Ribble Valley Borough Council
Housing & Development Control

Your ref: 3/2023/0488
Our ref: D3.2023.0488
Date: 6th June 2024

Application no: **3/2023/0488**

Address: **The Old Printworks 4a and 6a Back York Street Clitheroe BB7 1LT**

Proposed Floor Plans 1:100 @ A3

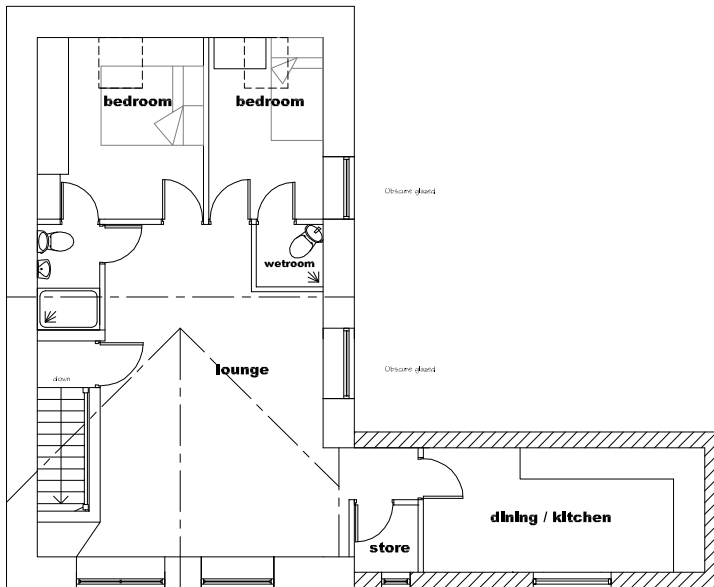
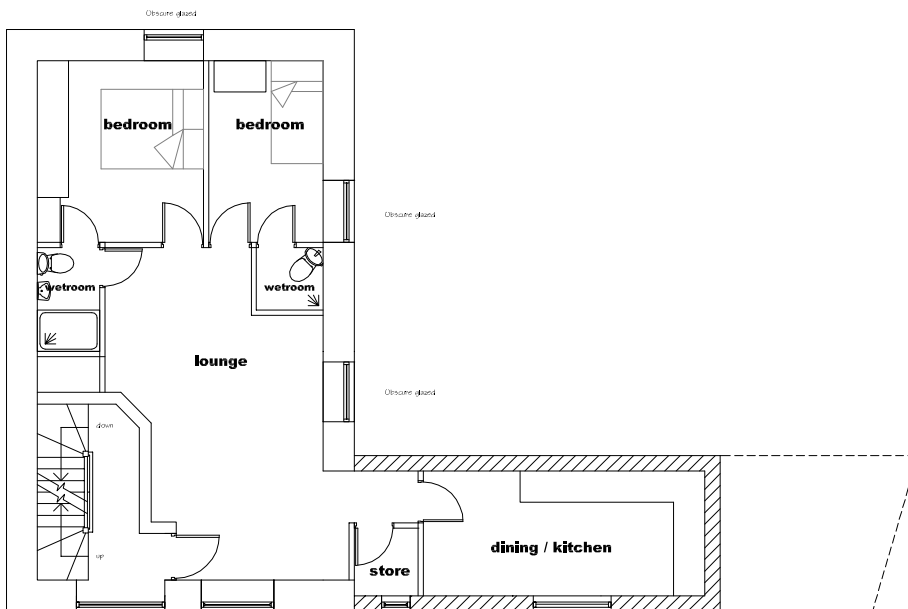
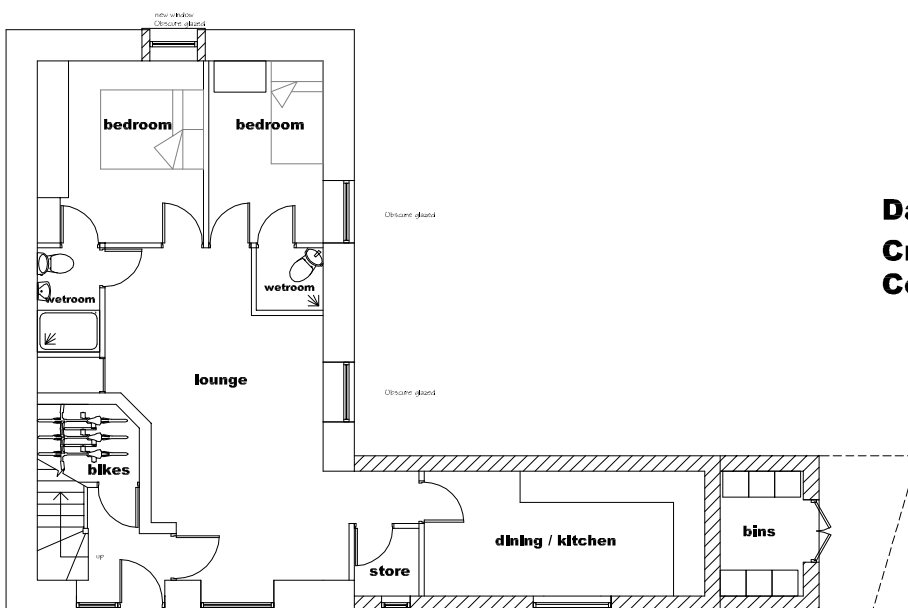
The LHA also welcome as shown on Dales Design drawing titled "Proposed Floor Plans" cycle storage facilities for the occupants being provided following the shortfall in parking. The LHA will condition this and will request that each flat has access to a minimum of one cycle space.

2. No development shall commence until details of covered and secure cycle storage facilities have been submitted to, and approved in writing by, the local planning authority. Secure covered cycle parking should be provided at a level of:

- 3 cycle parking spaces.

Details should accord with Lancashire County Council parking standards with the scheme being implemented in accordance with approved details before first occupation / use of the development with the facilities being retained at all times thereafter.

Former Castle View Print Works
Back York Street
Clitheroe BB7 1LT
Existing Elevations 1:100 @ A3
Showing Demolition Scaffolding

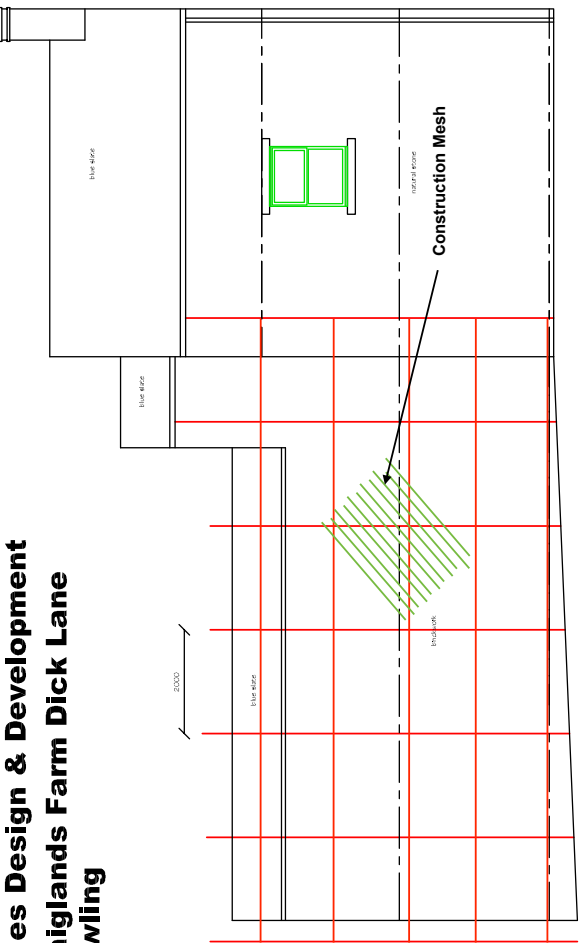
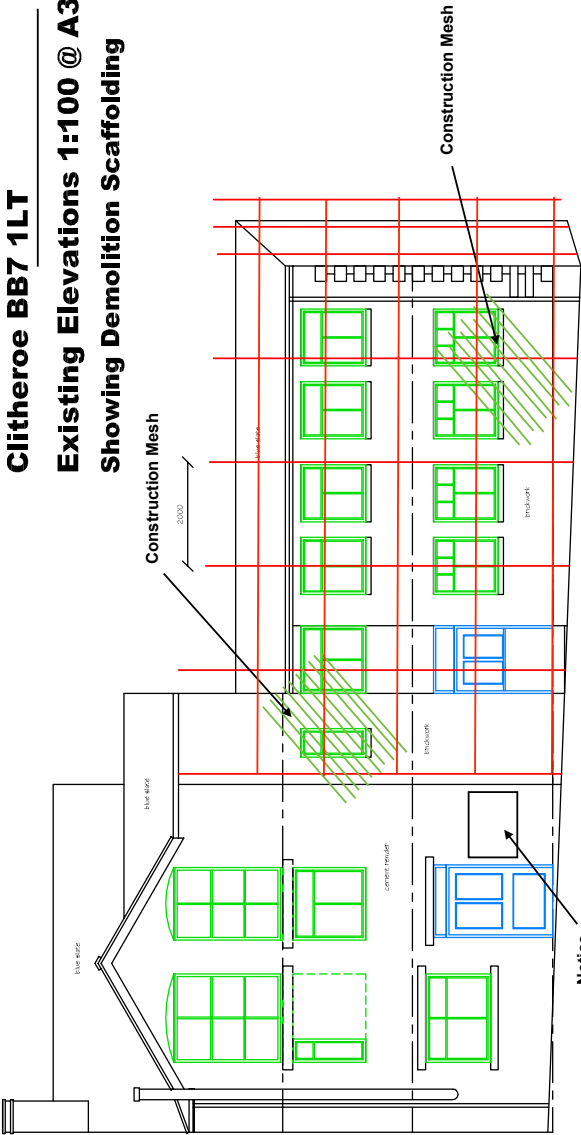
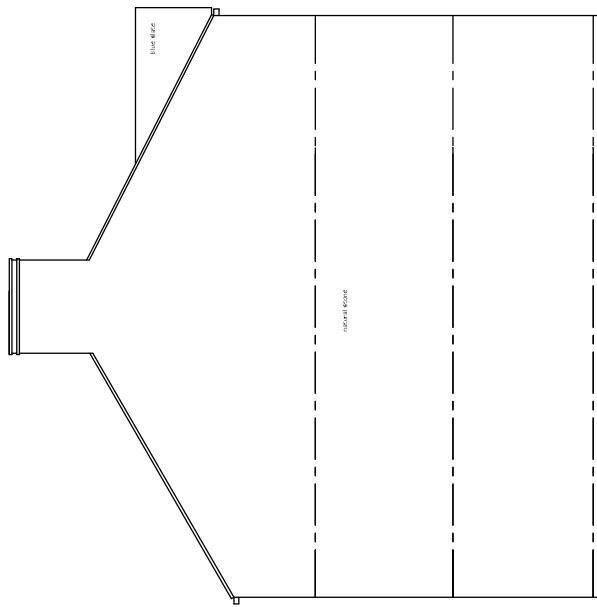
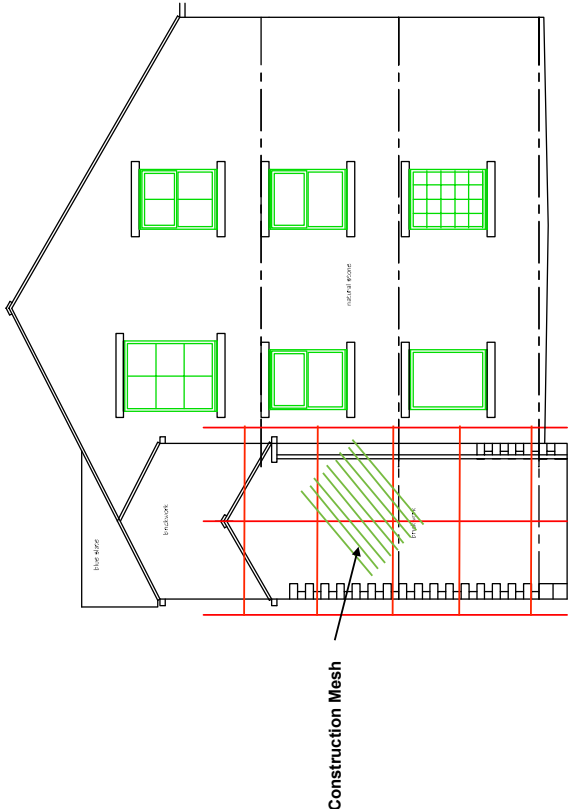
The LHA advise strongly that a site meeting is scheduled between the LHA, the LHAs Streetworks team and the contractors to discuss the construction phase prior to the discharge of the pre-commencement condition. This way the LHA can assess whether a road closure is required along Back York Street whilst scaffolding and site hoardings are implemented, and further discussions can be had with the contractors regarding highway safety.

discuss the construction phase of the development and to fully assess whether a road closure is required for highway safety reasons during this phase. Any agreements following this meeting then needs to be stated within the amended Construction Management Plan which then needs to be used to discharge the pre-commencement condition.
